## PLANNING CONSULTATION RESPONSE

<b>Application No</b>	2025/0908
<b>Proposal</b>	Re-engineering and Restoration of Yew Tree Quarry through the importation of non hazardous Excavated Soil Materials
<b>Address</b>	Stairfoot Brickworks, Wombwell Lane, Stairfoot, Barnsley, S70 3NS
<b>Date of Consultation Reply</b>	30/03/2026
<b>Consultee</b>	Highways Development Control

VIEWPORT 3 - SWEEP PATH ANALYSIS (SCALE 1:1000@A1)

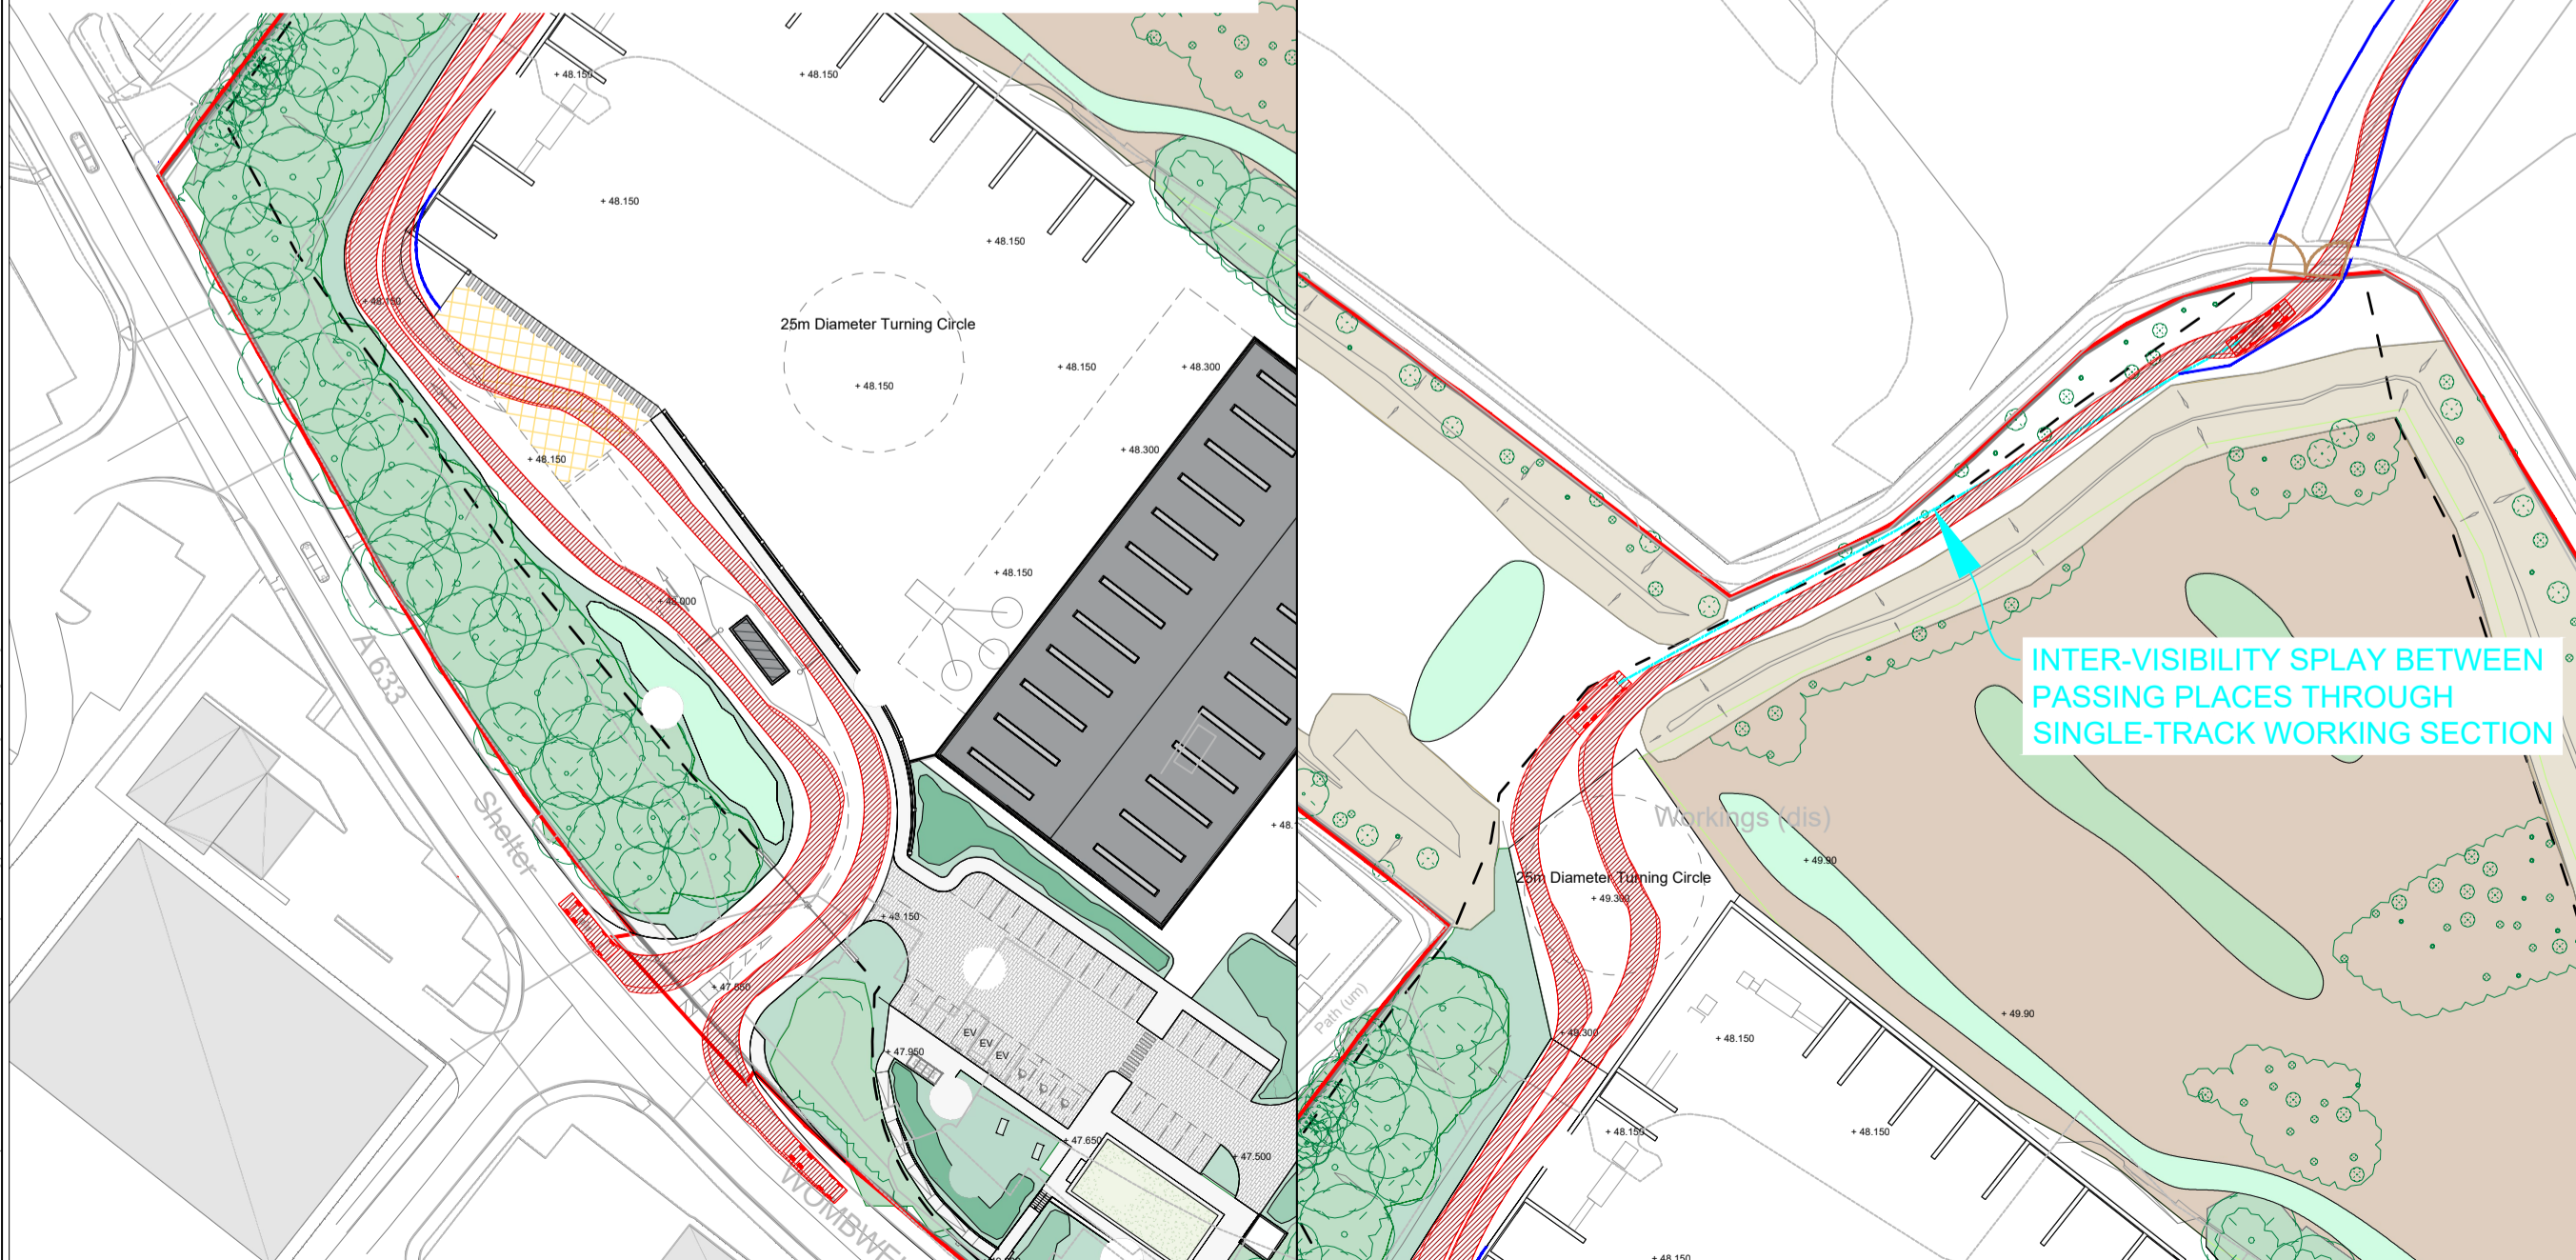
I note that the applicant is reliant on the site access works being brought forward and completed by the site owners of the former Stairfoot Brickworks site. However, at present, works to construct the access to an approved standard have yet to commence. This introduces a degree of uncertainty in relying on the proposed access arrangements to manage vehicle movements safely and effectively. Furthermore, I note within sections 4.2.4 and 4.2.5 of the delivery management plan, it states -

This clearly indicates that platoons of up to 5 or 6 HGVs could arrive at the site at the same time, with the potential for up to 11 vehicles to arrive at the same time. Given that the access arrangements are linked to the wider former Brickworks permission, I would also query whether sufficient consideration has been given to the combined vehicle movements arising from both sites operating concurrently. As you will be aware, a gated access was approved, with the gates set back to accommodate a single waiting HGV only. Any additional vehicles arriving at the same time would therefore be required to wait on the public highway, which would be likely to result in

disruption to the free flow on traffic on what is a sensitive and heavily trafficked section of the local road network.

On this basis, I remain concerned that the proposed delivery and access arrangements, as currently presented, do not adequately demonstrate that HGV movements can be managed without giving rise to potential highway safety or operational issues. Consequently, at the present time I would be required to raise an objection on this basis or alternatively request that you defer a conclusion pending the submission of any further information capable of addressing the issues identified above.
